## Newcastle Gas Storage Facility Tomago, NSW, Australia

Comments by Craig Rivera  
13 December 2012

Figure 2: Design of Concrete Washout Skip

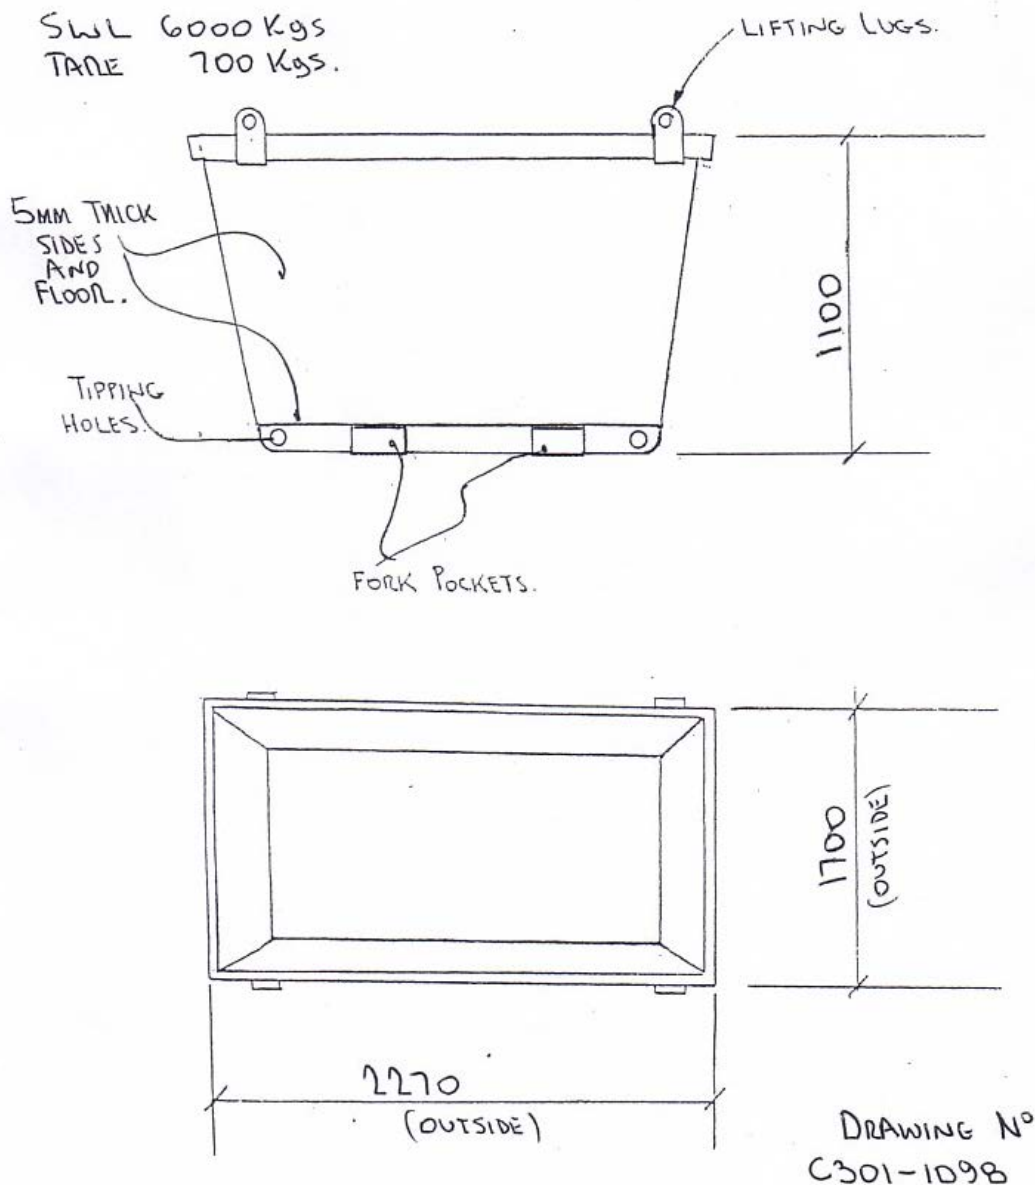
Is there any marker or indicator on the skip to the operator washing out the truck when desirable capacity has been reached?	p5, 4.5.1 – added: The skips will be clearly sign posted have a marker to indicate when the acceptable maximum capacity is reached.
Can you please clarify the frequency of pump-out truck movement?	p4, 4.1.2 – added: It is anticipated that 6 concrete trucks will be in use at any time during concrete pours.
Further to the last dot point in my email of 23 October (see email chain below), my initial question regarding the frequency of movement for the pump-out trucks has not been included in the updated mod document. Rather it states that this will be reflected in the Traffic Management Plan (TMP) - as stated in point 4.25 on p.5 of the mod document, "All movement of concrete trucks on site are to be managed under the Site Traffic Management Plan. This management plan shall allow for the quantity and frequency of trucks as well as scheduled waste removal, ie. emptying the concrete washout skips." If the Site TMP has been updated to reflect the proposed mod, do you have a copy (or at least part showing the relevant amendments)?	p4, 4.1.1 – added: A site traffic management plan will be updated to coordinate onsite concrete truck movements with other ongoing onsite construction works at the time. The plan may be changed daily to suit the internal construction traffic conditions on the day. This plan is different to the Traffic Management Plan which was approved by the Department of Planning and Infrastructure in August 2012 which deals with all offsite traffic.  Delivery of concrete to site is within the scope of the Traffic Management Plan.

Figure 3: Location of Concrete Washout Skip Bins during Construction Works

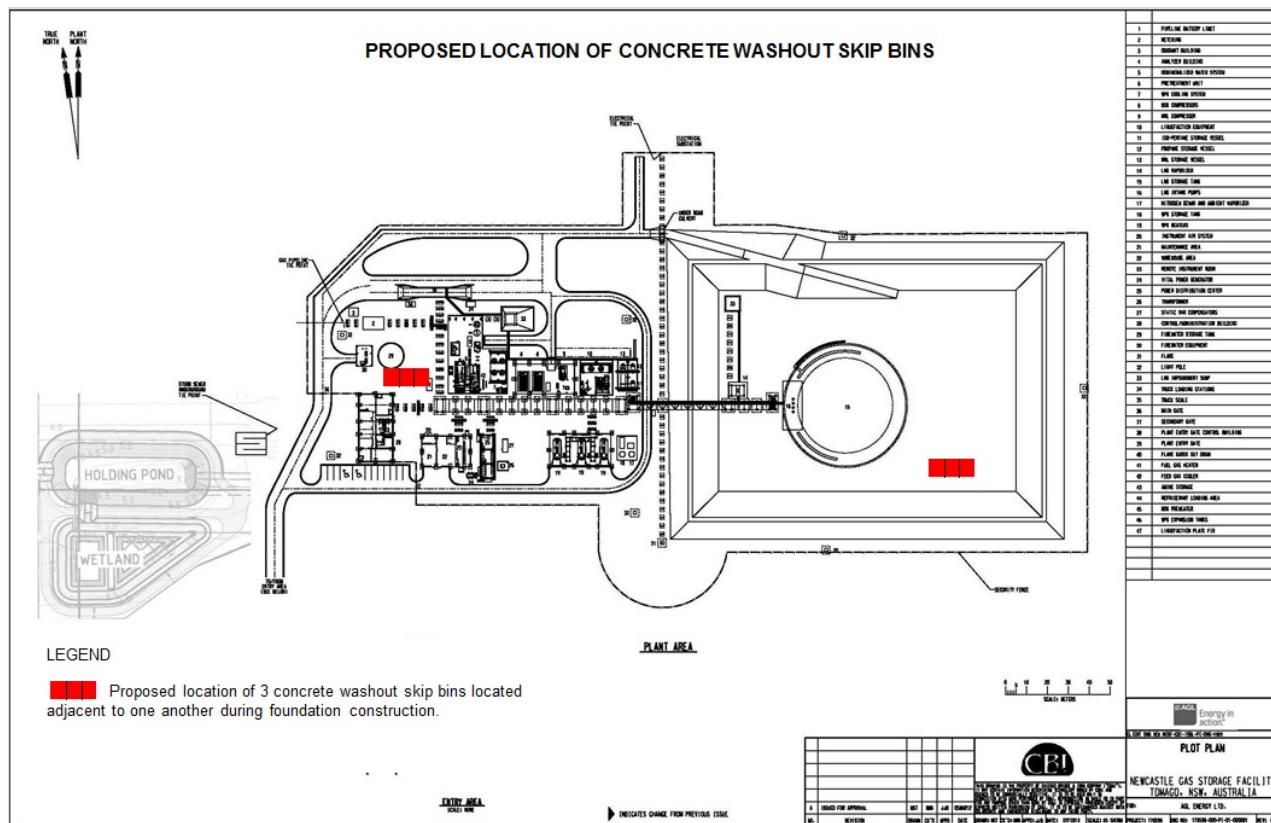
DoPI Comment	CBI Response
As noted in para 3 on p.4 of the CB&I document 2, there will be 3 x 3 cubic metres skip bins, with a combined capacity of 9,000 litres (ie. 1 at 3,000 litres). The largest concrete pour will be approx 450 cubic metres producing 5,000 litres of waste water. This would be from one concrete truck. By my reckoning this will probably fill 2 x bins - allowing for bins not to be filled to capacity prior to pump-out.	p4, 4.1.6 – added the word waste after the word water at the end of the sentence. This volume of water would be produced from over 70 trucks.
Figure 3 on Page 7 shows the location of concrete skips - however, I note that the legend refers to "proposed location of concrete washout skip bin during foundation" - I initially thought that this was the location of one skip (which may have led me to ask where the third would be located).  Can you please clarify whether all three CWS are to be located adjacent to one another at the two locations noted?	p7, Section 4.6, Figure 3 – this figure has been revised to clarify this.
